AL/101/18/PL

Comments from Chris Bartlett – WSCC

LAND ADJACENT SRC RECYCLING
FONTWELL AVENUE,
EASTERGATE
WEST SUSSEX PO20 3RU
SITE PLAN
SCALE 1: 500 @ A.4
DWG NO FA18/01

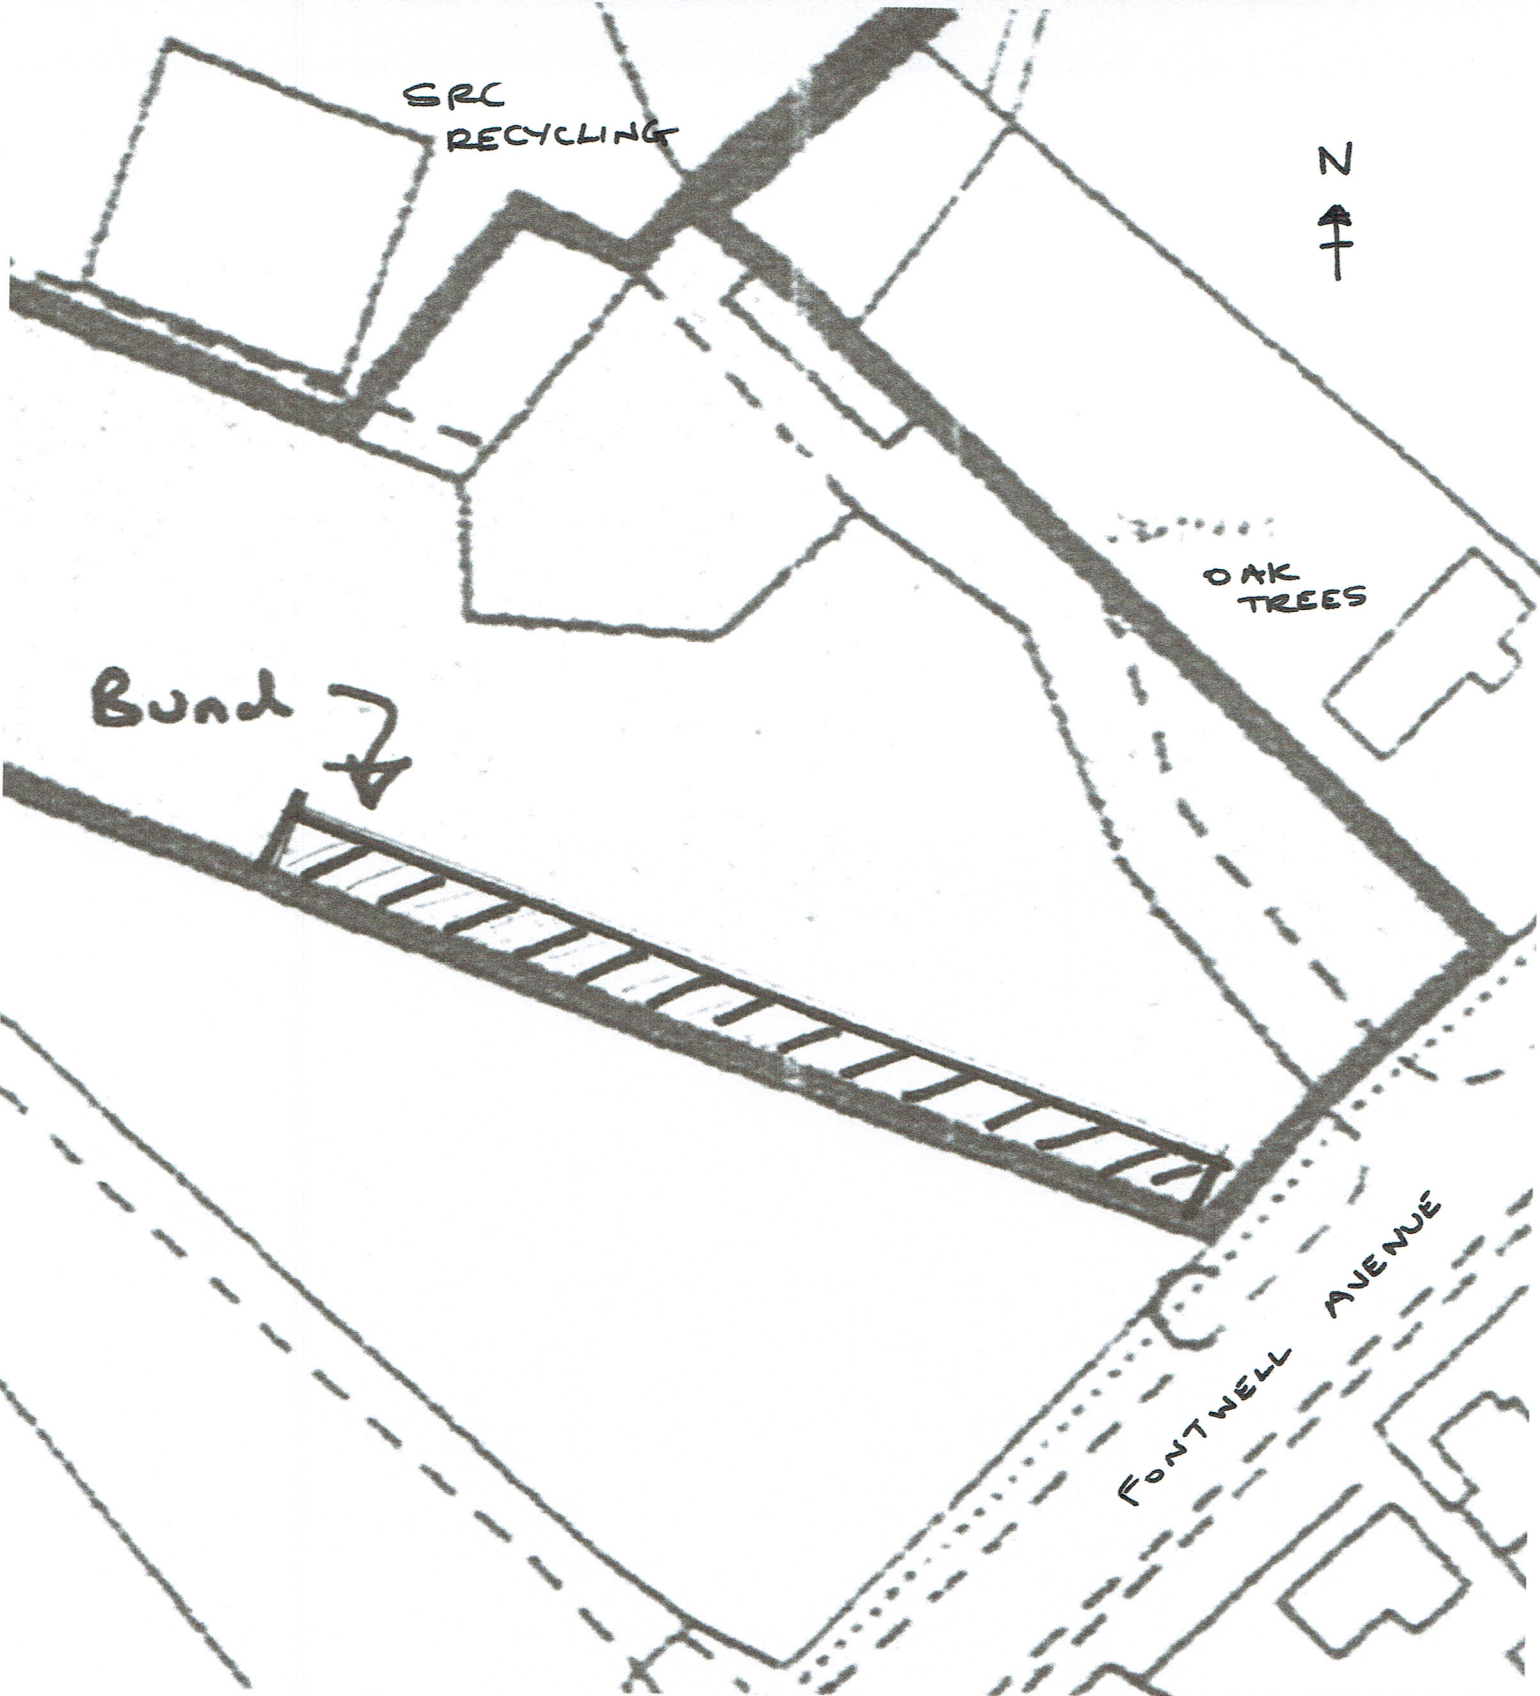
Although the applicant states that the bund is to comprise topsoil from the adjacent site, we'd still class this as 'inert waste' and therefore should be appraised using the Waste Local Plan policies. I'm guessing that they are taking soils from the adjacent housing development site and simply placing it a bund and is therefore a development in its own right.

Clause (e) is more complicated; it is impossible to establish whether the amount of material to be used is the minimum necessary to deliver the benefits identified, as no benefits have been identified. The applicant should be asked to justify the amount of waste they are proposing to import and the scale of the landform.

You'll also need to reassure yourself that there would be no unacceptable impact on natural resources (clause (f)), and that the restoration/aftercare of the site would be of high quality (clause (i)). No information is provided for restoration/aftercare, not even stating that the bund would be seeded with grass and no timescales or maintenance details have been provided.
